City of Albuquerque

RE: TUMBLEWEED PARK SUBD LOT 11 (L-10/D13F)
(Bell Ave SE)
ENGINEERS CERTIFICATION FOR CERTIFICATE OF OCCUPANCY
ENGINEERS STAMP DATED 9/15/2000
ENGINEERS CERTIFICATION DATED 6/12/2001

Re: T.C.L. submittal for building permit approval for Warehouse for Bob Jacobs, [L20/D013F],
9916 Bell Ave. N.E., Tumbleweed Park Subd., Lot 11.
Architect's Stamp not clearly dated or signed.

TRAFFIC CIRCULATION LAYOUT CHECKLIST

SHEET SITE PLAN AND LANDSCAPING PLAN

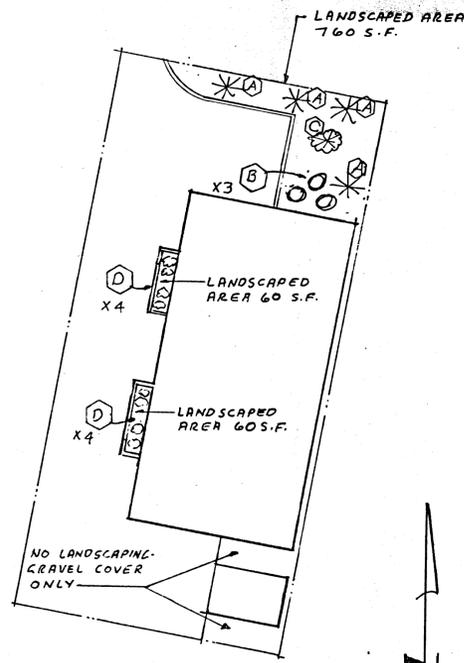
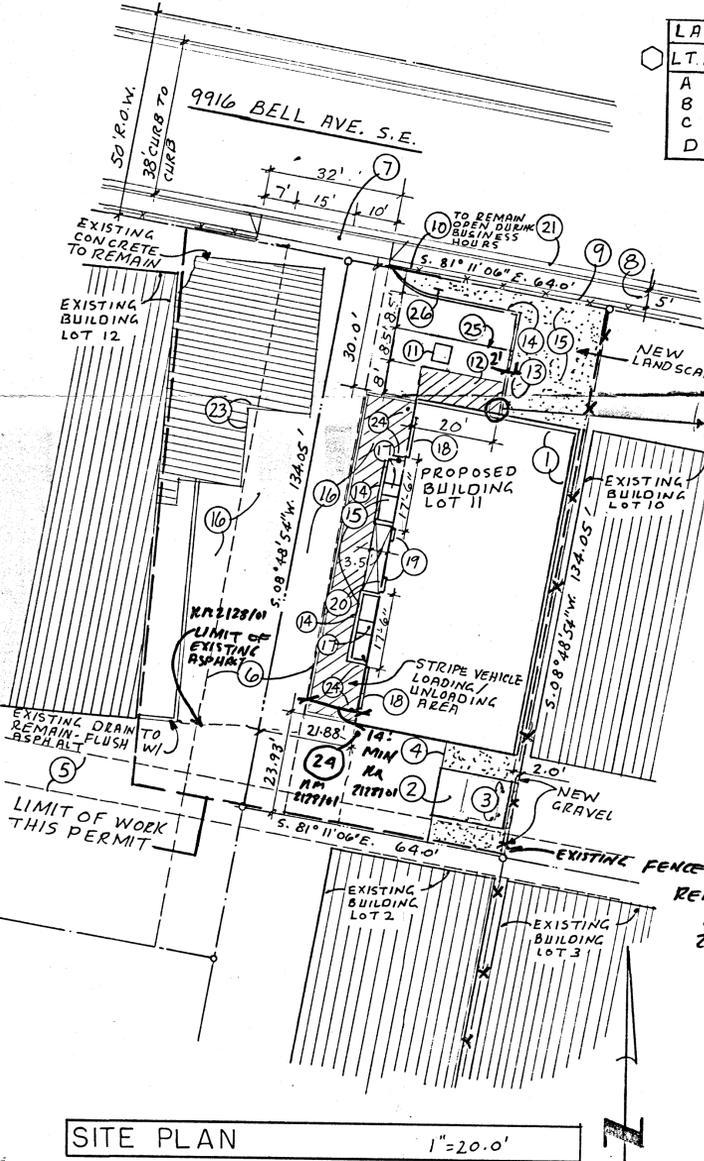
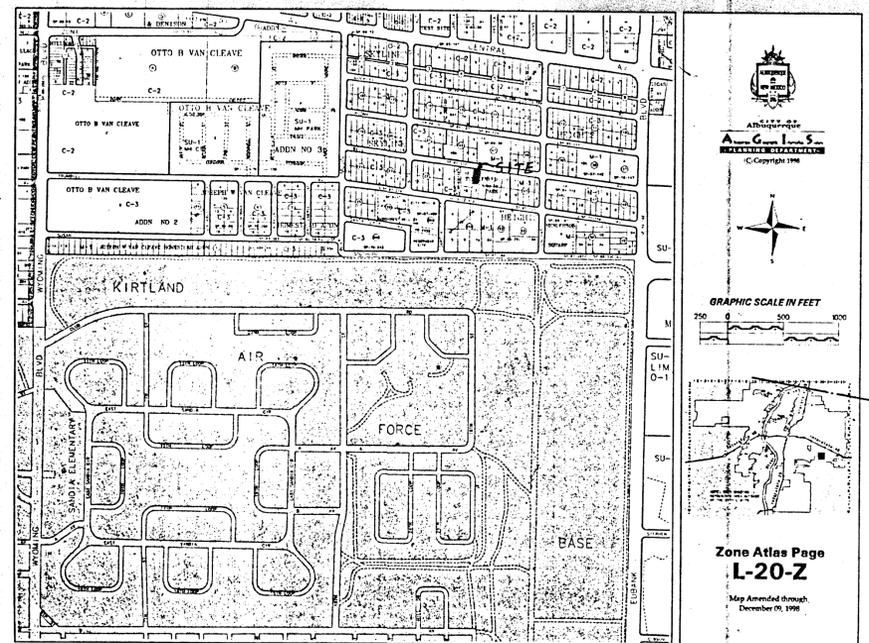
- ☐ 1. Place on all subsequent TCL's as applicable – 15' radius at curbing near the entrance, all drive aisles and street sidewalk width dimensions.
- ☐ 2. TCL stamped by the architect must be signed and clearly dated.
- ☒ 3. Street address of site - could be part of title block or Drainage Application sheet in Hydrology file.
- ☒ 4. Name of subdivision and lot number or tract number on TCL, if not on Drainage Information Sheet.
- ☒ 5. Indication of transition from one type of surface to the other on TCL, for example ramps (incl. H.C.), concrete/ asphalt, landscape area/ concrete, concrete / dirt, concrete /gravel, etc. Label each area or stipple to show varying surfaces, using a legend, or equal.
- ☐ 6. The responsibility for errors on the site plan and subsequent unauthorized field changes must be specified on the TCL, in bold type, as follows:

- ☒ 13. State Highway Department approval at locations where access improvements are being made from State Facilities.
- ☐ 14. Call out on Site Plan: INSPECTION OF CONSTRUCTION FOR C.O., FOR TRANSPORTATION, WILL BE DONE FROM THIS SHEET, once minor changes to the TCL (Site Plan) required by Transportation are verified as acceptable to Hydrology.

- ☐ 15. State what type/size of vehicular activity occurring at the rear of site?[cr.]
- ☐ 16. Show new and existing elements on the T.C.L., labelled, and dimensioned correctly: fencing, retaining walls and site walls.

- ☐ 17. Show clear differentiation between new construction and existing improvements on TCL.
- ☒ 18. Indicate which buildings and parking improvements will be certified by this permit. Show future work in line type that is clearly different than for new work.

- ☐ 19. Show, label and dimension all existing obstacles in City right-of-way, in existing sidewalks.
- ☒ 20. Callout to label on asphalt "COMPACT" or equal for small car stalls, at end of stall.

- ☐ 22. H.C. ramp must be constructed at H.C. parking area as part of sidewalk.
- ☐ 23. Proposed use of overhead doors on commercial sites requires that plan reviewer looks for large wheelbase (refuse/UPS) vehicle to be smallest to use doors. Refer to DPM for restrictions. Parallel parking of loading/unloading trucks, with painted loading area, as shown, will be the only way the overhead doors can be used for this warehouse application.

- ☒ 24. Call out to restripe existing lot per City Standard.
- ☐ 25. For future reference, and for this project, show half width of all streets 40' wide and over on TCL, also for streets used for large truck traffic accessing site. This is to include median and opening, if it exists (including any left turn lanes into this site). If no medians exist, show traffic lanes on developer's side of street, up to and including middle turn lane.

- ☐ 26. The drivepad will need to be widened to accommodate a loading truck at the northernmost overhead door, as shown.
- ☒ 27. Need to see alley right-of-way limits. Show full width of alley and all obstructions and label paving.

28. Alley limits must be expanded to minim. 20' width.

29. A City standard paved alley roadway must be constructed along the entire lot frontage and constructed to one point of access into the alley, from that street.

30. Alleys must be minimum 24' at entrance as access to parking area. Construct alley entrance per City Std. Detail Dwg. 2428.
